Addendum No. 1

RE: Contract ID C203015
WBS # 34839.3.10
F. A. # HPPNHF-0918(46)-0-
Forsyth County (U-2579G)
Bridge #366 Over US-421 On SR-2667 (Hastings Hill Road)

October 16, 2012 Letting

REVISIONS						SHEET NO.
NO.	BY	DATE	NO.	BY	DATE	W-5
1	SCC	10-4-12	3			TOTAL SHEETS
2			4

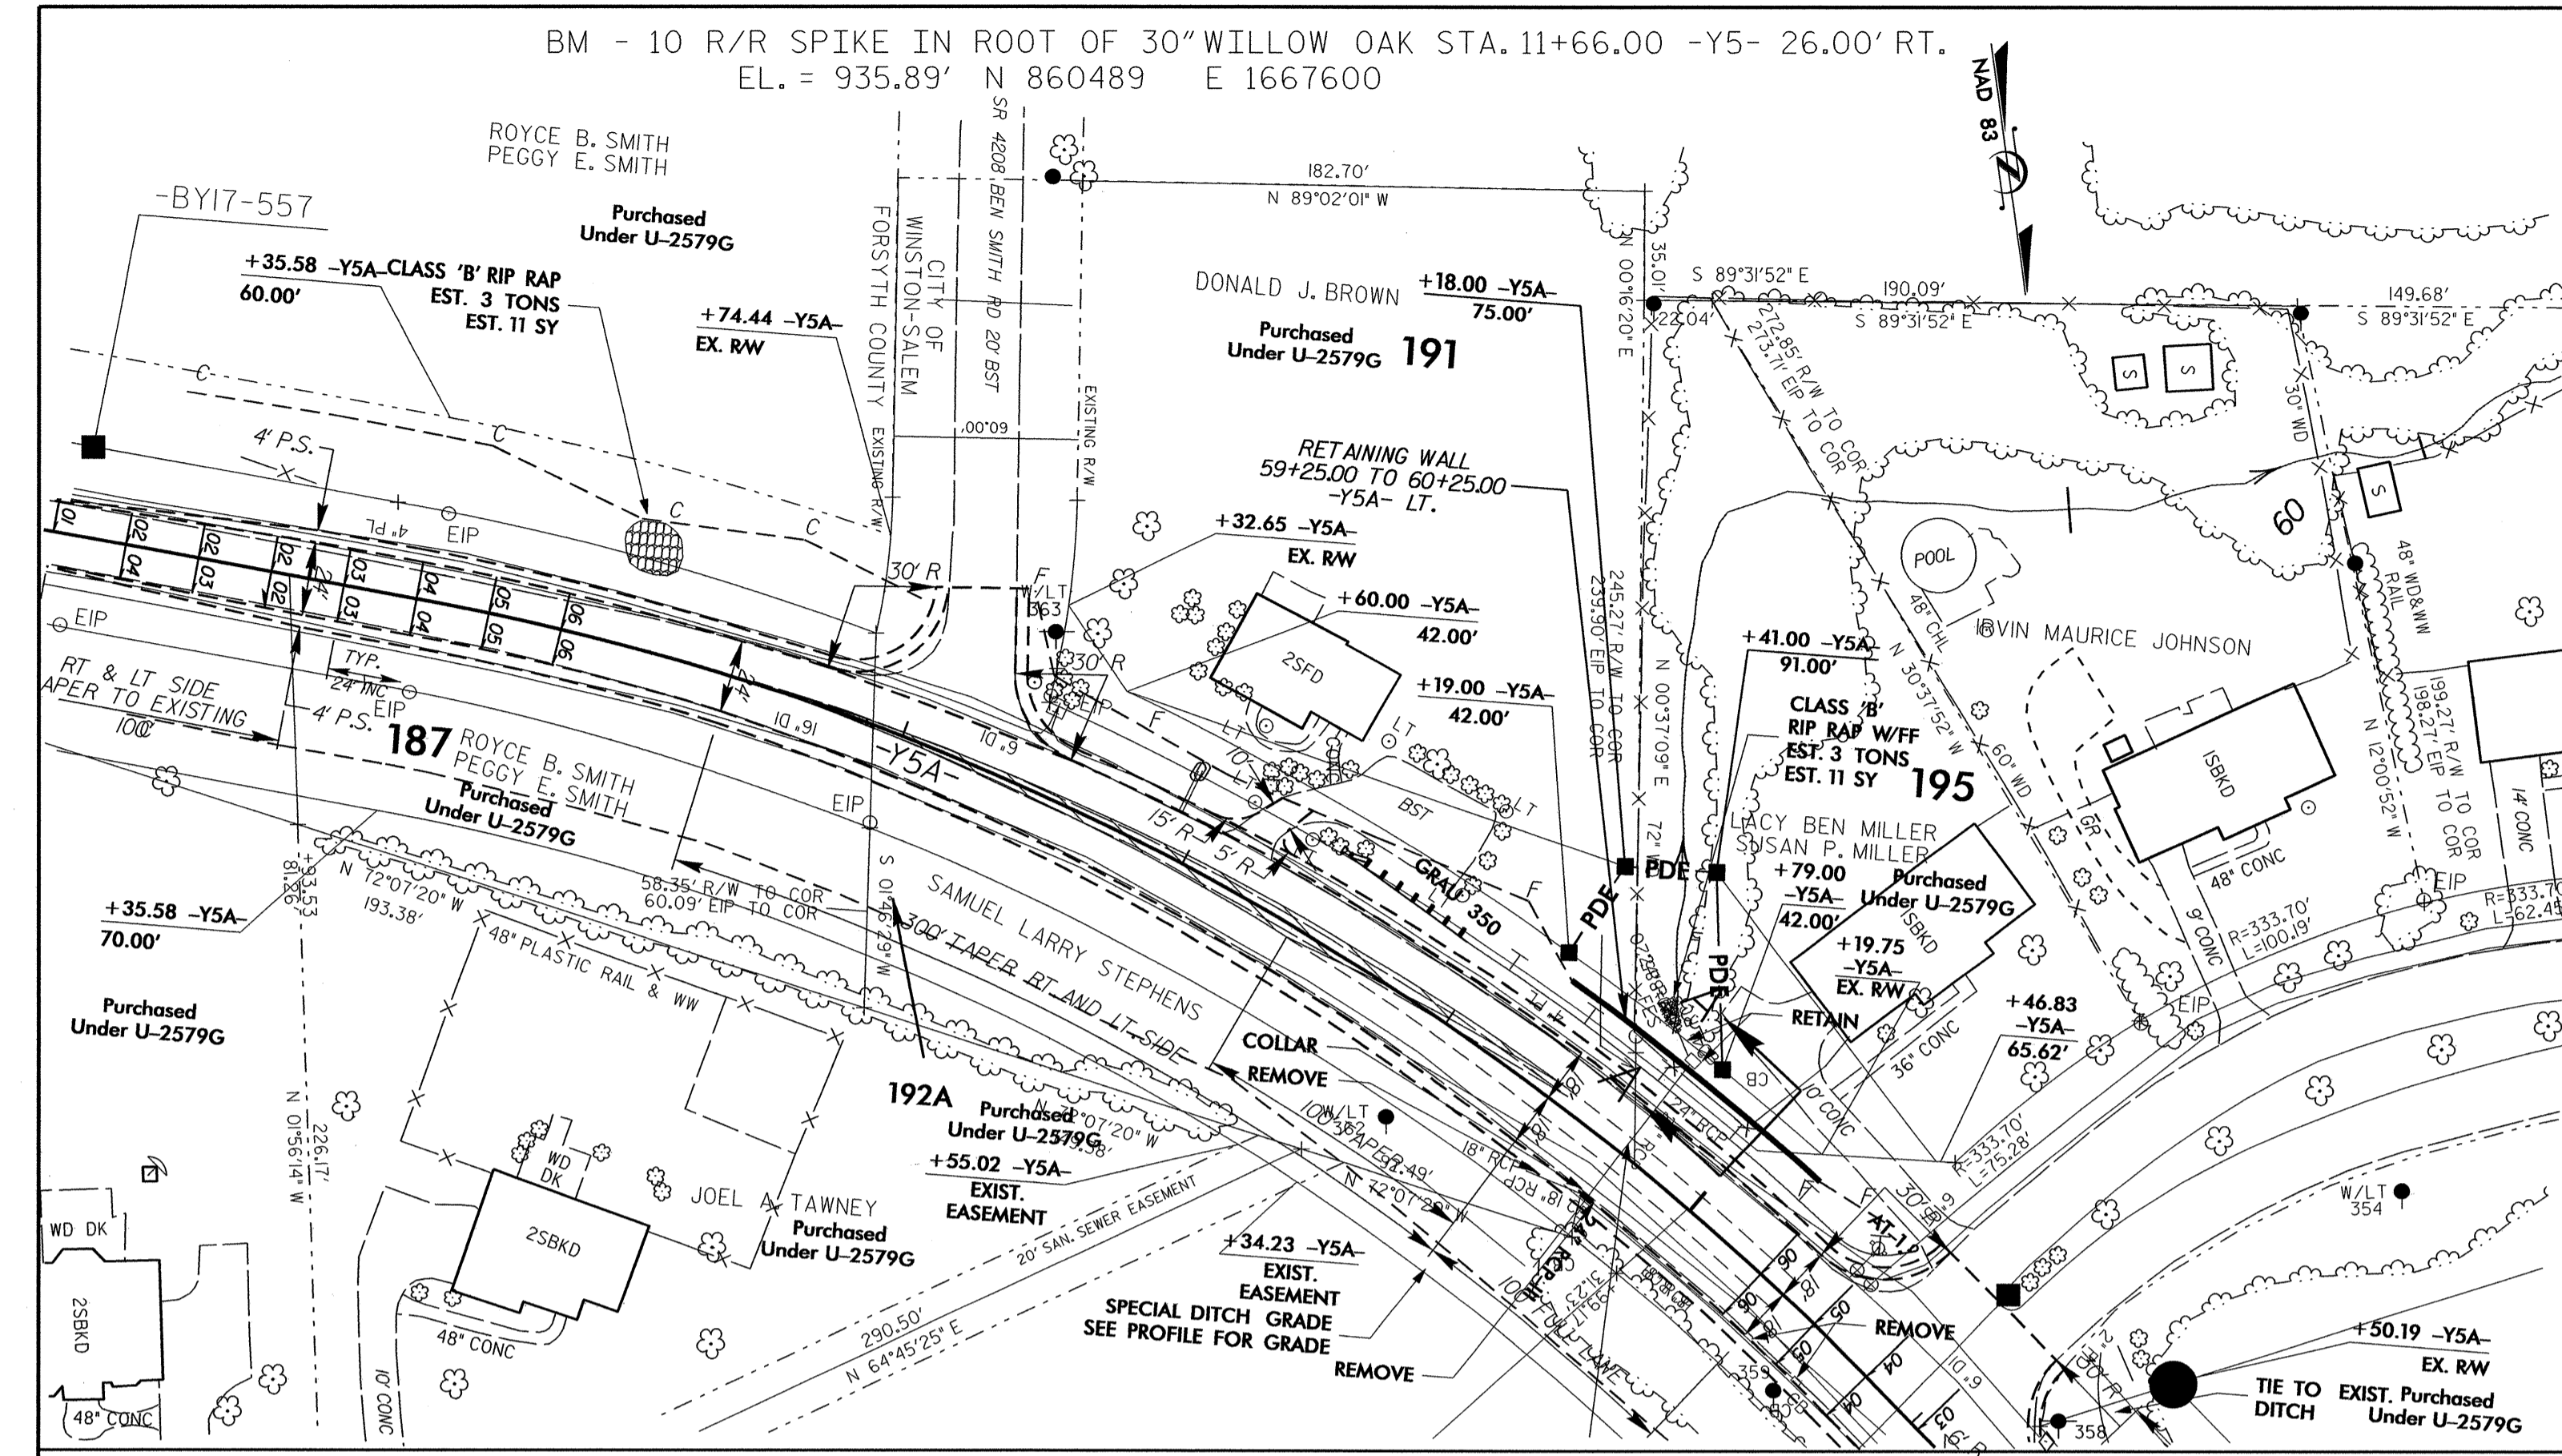
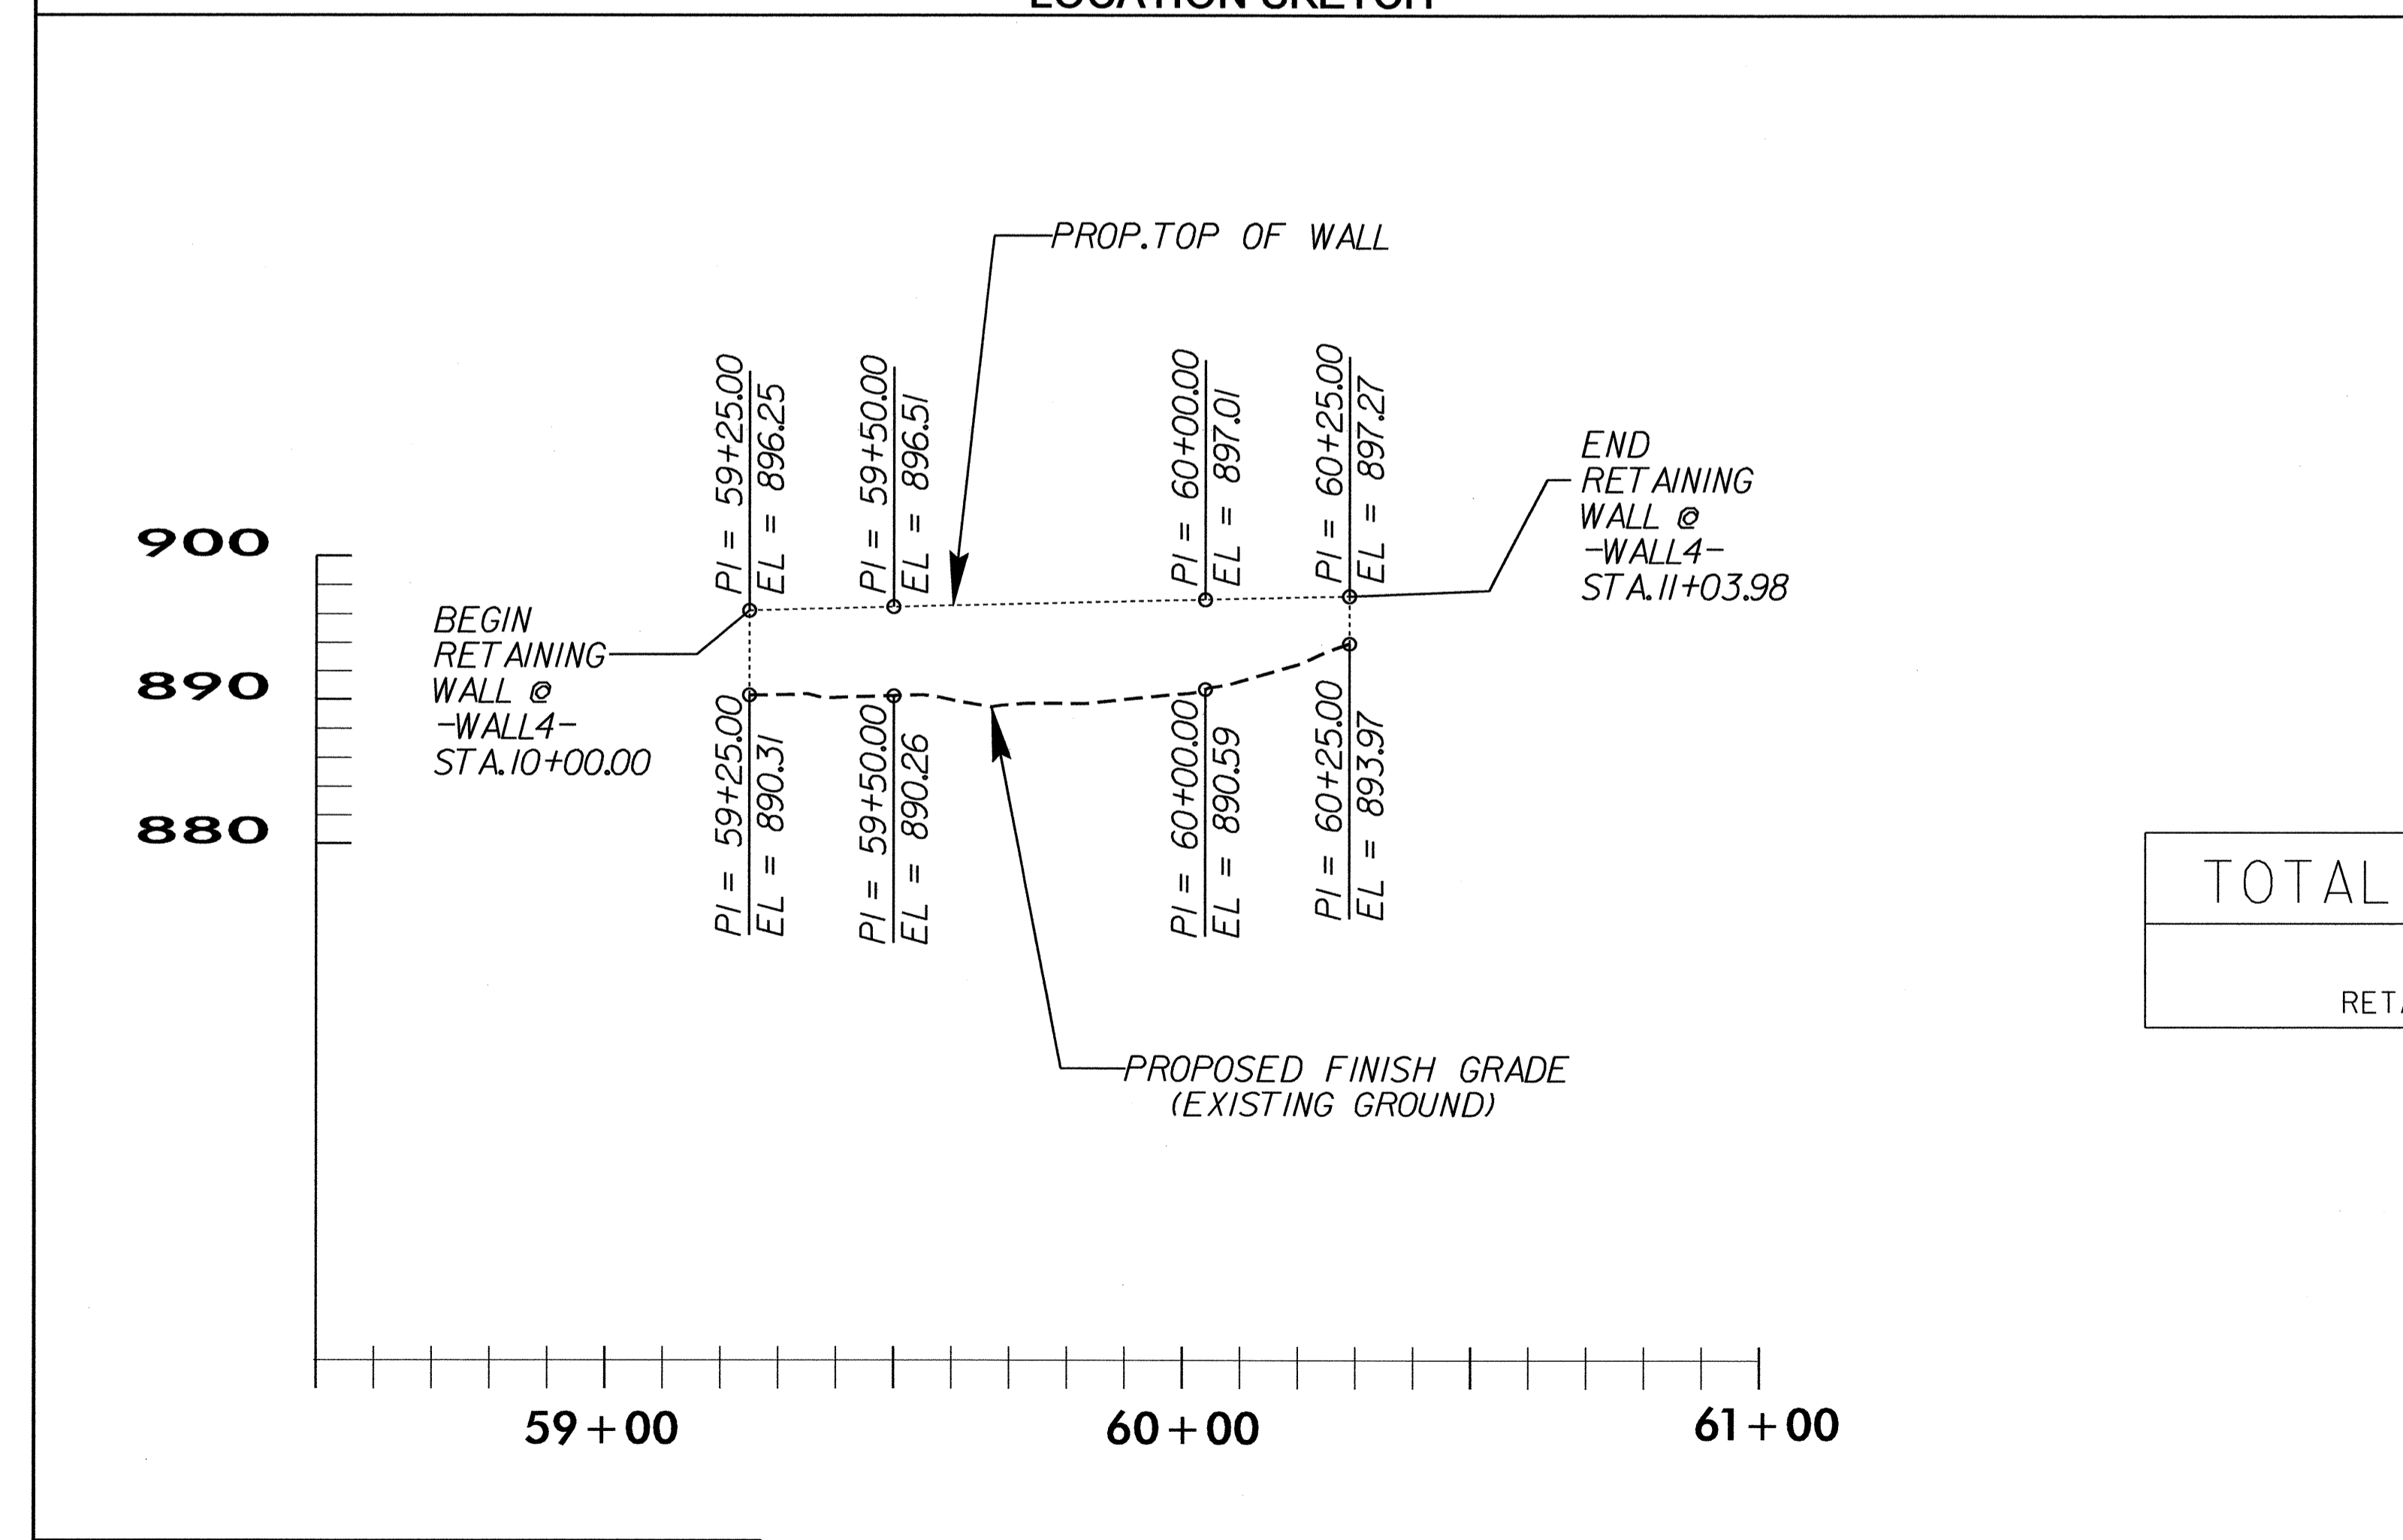
On Sheet No. W-5 the "Maximum Factored Vertical Stress On Foundation Material" value has been revised. Please void Sheet No. W-5 in your plans and staple the revised Sheet No. W-5 thereto.
